Fwd: Thompson's Point

From: **Barbara Barhydt** <bab@portlandmaine.gov>
Date: Mon, Jan 23, 2017 at 4:07 PM
Subject: Thompson's Point
To: "Dobson, Lannie" <ldobson@portlandmaine.gov>
Cc: Christine Grimando <cdg@portlandmaine.gov>

You asked about what review would be needed for the Bissell Borthers outdoor seating.

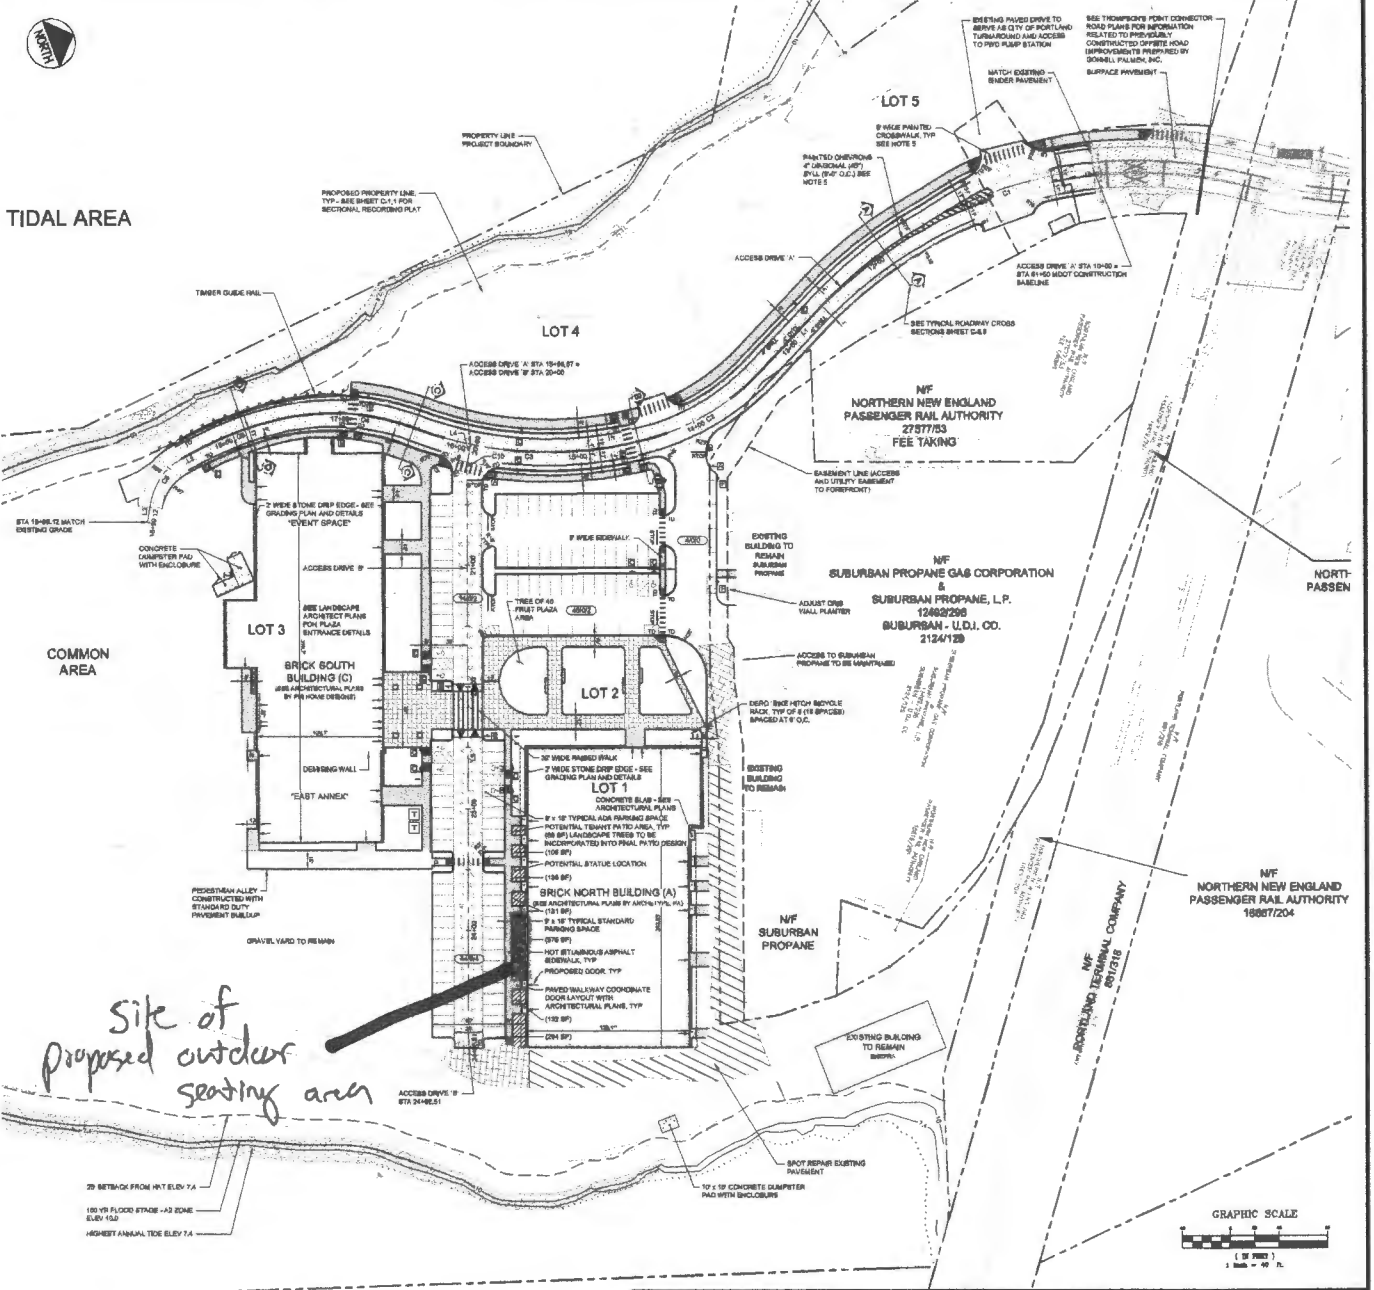
I looked at the approved plan for this site and landscaping is proposed along the frontage. The plan shows changing the green space to pavers, so that is an increase in the impervious surface area. There are no dimensions on the plan, but if it is less than 1,000 sf. then it could be done as an administrative authorization. If it is more than 1,000 it would need a Level I site plan or possibly an amendment to their site plan application from 2014, but I think that one is closed out.
